From: Martyn White
Sent: 13 December 2018 15:07
To: Planning.Responses
Cc: Anita Gardner
Subject: CM/31/18/L

CM/31/18/L

The proposal is to introduce an internal window into the property. It is evident from the information supplied that a significant amount of work has historically been undertaken to the property.

Ground Floor - Proposed

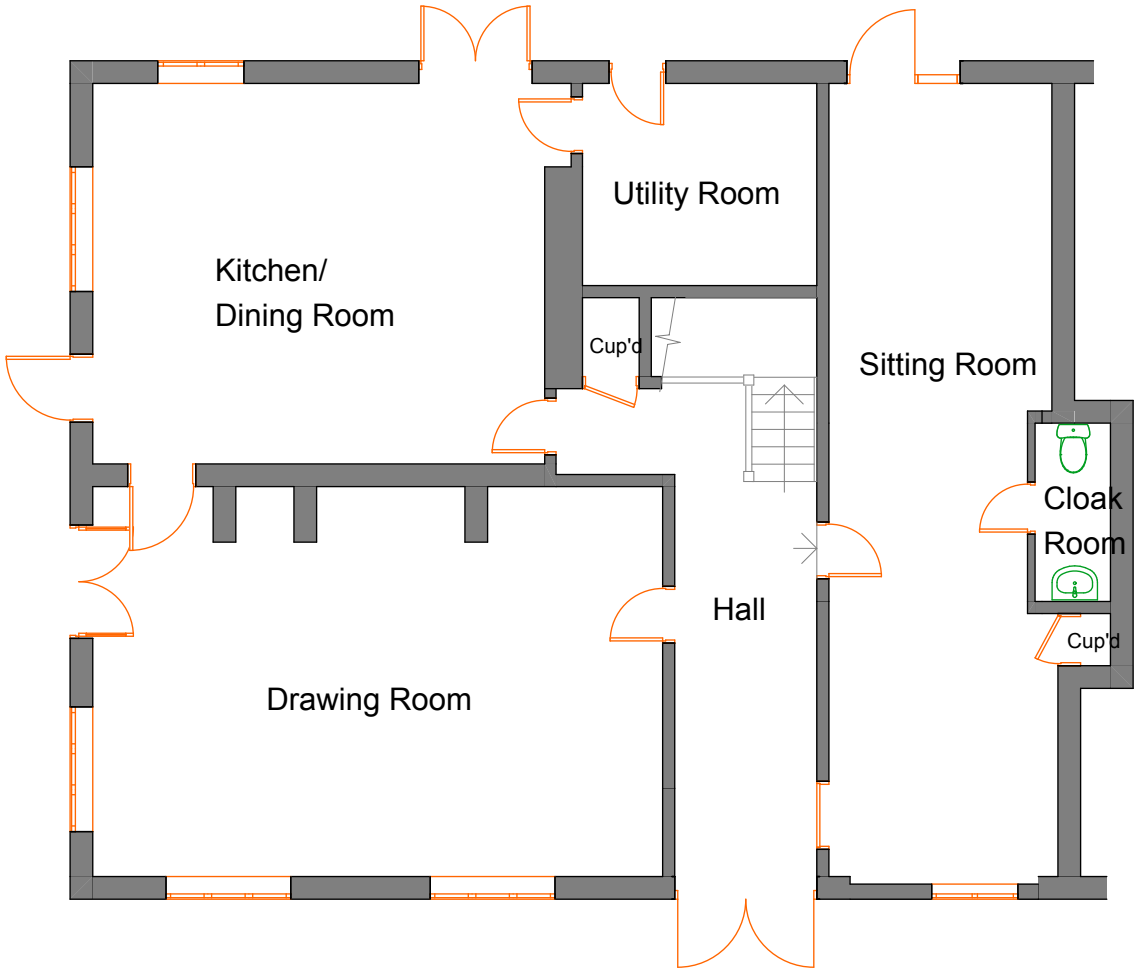
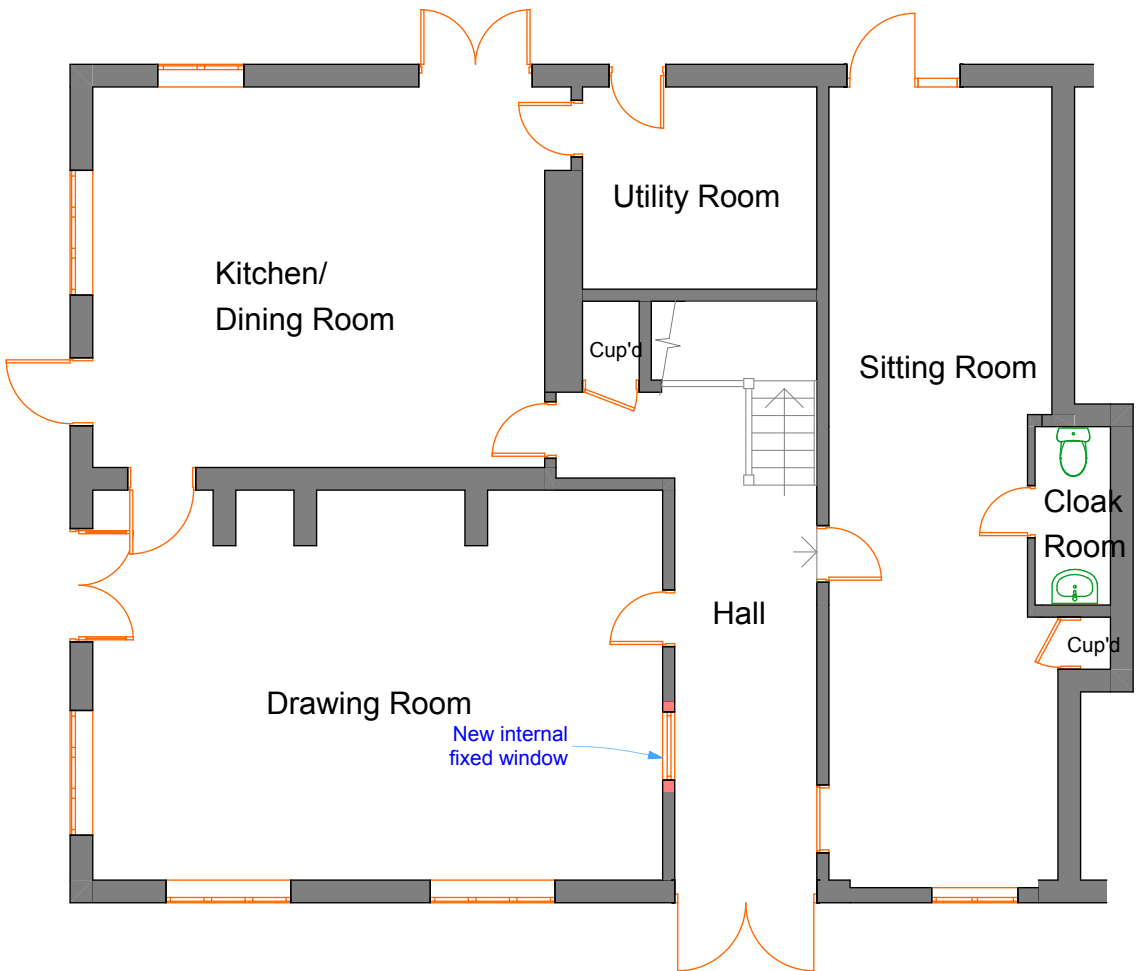
Reference is made to the fact that the window would provide light for the hallway and sitting room. The window is small in terms of scale and appears to affect modern fabric. It would be helpful to know how the window will be treated i.e. painted or stained? On that basis the proposal will have a neutral impact upon the character and, in this instance, is capable of support.
